Road Safety Audit Stage 1 (Feasibility)

Location: Phase 3 Toddington Lane,
Littlehampton. Parcel A2.B6

Project Name: Toddington Lane, Littlehampton. Phase 3 - Parcel A2 and B6

Report Title: Stage 1 Road Safety Audit
Proposed S278/38 highway works

Org No:
544_PL_110

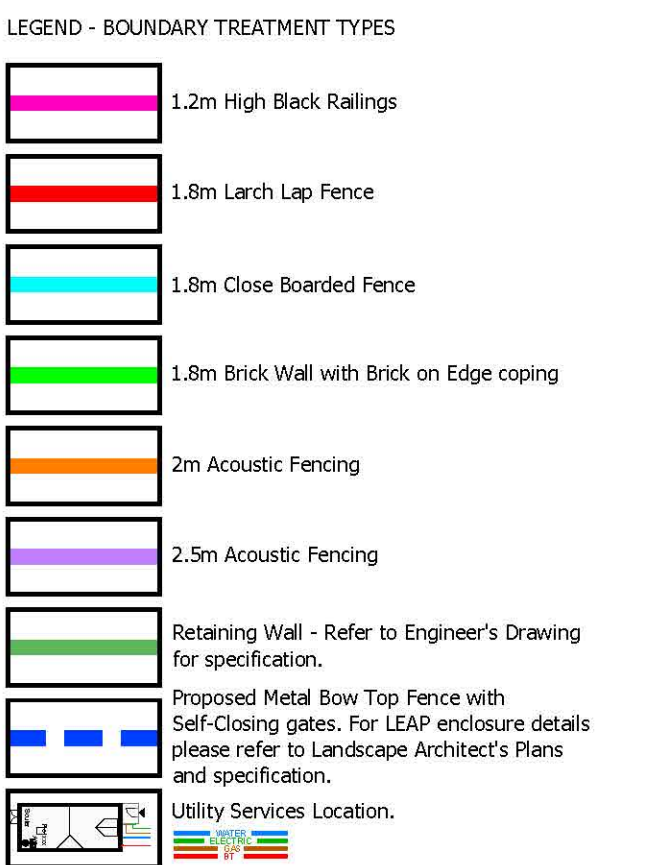
Description: A new road layout is detailed with priority given to vehicles exiting from the side road cul-de-sac near the main access into the site. This unusual priority arrangement may result in vehicles tailing back across the junction, possibly restricting access/egress to and from the development.

Description: There is a side road junction close to the main access. Vehicles exiting the side road need to keep to the left to avoid blocking the main access.

Description: A new pedestrian crossing point is detailed. There is reduced visibility for pedestrians crossing from in front of Plot 5 and no crossing point across the cul-de-sac. Amend pedestrian footways / pedestrian crossing point to ensure adequate visibility, and provide pedestrian crossing point across cul-de-sac between footways.

8.1	Priority given to vehicles exiting side road rather than from rest of development	Yes, priority is given to adopted road providing access to Plots 1 to 5. Whilst this arrangement may be unusual, it is a deliberate design decision to highlight the vehicle crossover transition into the home-zone private residential route serving Plots 6 to 29.

8.2	Extend centre line into main access past side road junction to help position vehicles exiting and accessing the development to stop entrance getting blocked.	Unfortunately, the drawing copy audited incorporated a pedestrian crossing (between Plots 5 and 7) that had been introduced by the architect in error, giving the false impression of this being a junction access, rather than a vehicular crossing. I believe that this is where the confusion has arisen from. However, with this crossing subsequently removed for clarity, the white lining will be indicated continuing to give priority to the adopted road lengths serving Plots 1 to 5.

8.3	Reduced visibility at pedestrian crossing point and inadequate facilities	As detailed in my 8.2 response, this crossing was introduced in error but has now been removed from this vehicle crossover scenario.

8.3 Agreed . Crossing point now removed and additional crossing point added where required
